Consultation Response from KC, Conservation and Design
2020/94197 78, Wellhouse Green, Golcar, Huddersfield, HD7 4ET
Listed Building Consent for erection of two storey extension to side (within a Conservation Area)
Date Responded: 22/02/21 Responding Officer: Craig McHugh Responding Ref: CV2/267
Significance of the heritage assets affected

Proposed side elevation (1:100)

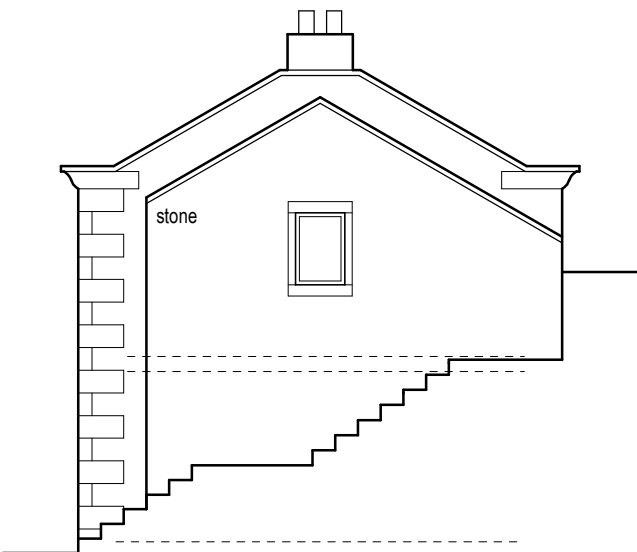
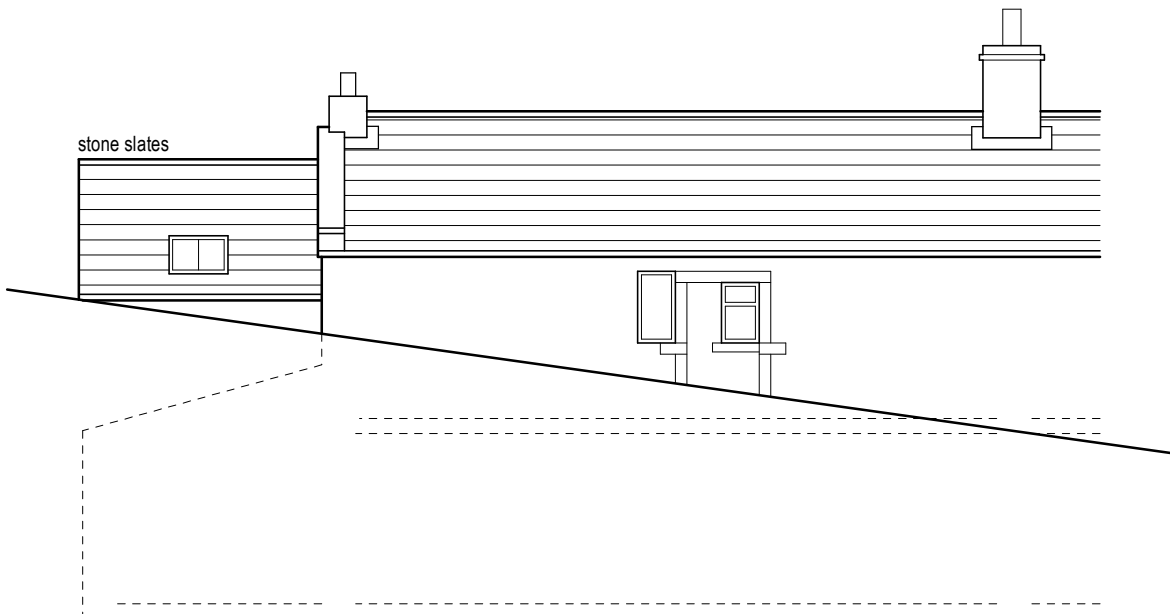
The proposed development would result in the loss of the lean-to extension, the first-floor windows and the blocked attic windows. The age of the lean-to extension is unknown. The window openings are original. The proposals would neither preserve nor enhance the listed building, they would cause a moderate level of harm, that harm would still be less than substantial harm.

particular regards to Section 16(2) of the Planning (Listed Buildings and Conservation Areas) Act 1990, Policy LP35 of the Local Plan and paragraphs 193 and 196 of the NPPF. Subject to a better understanding of the significance of the lean-to extension, a single-storey extension on the footprint proposed could be acceptable in principle. As currently submitted, the application should be refused or withdrawn by the applicant.
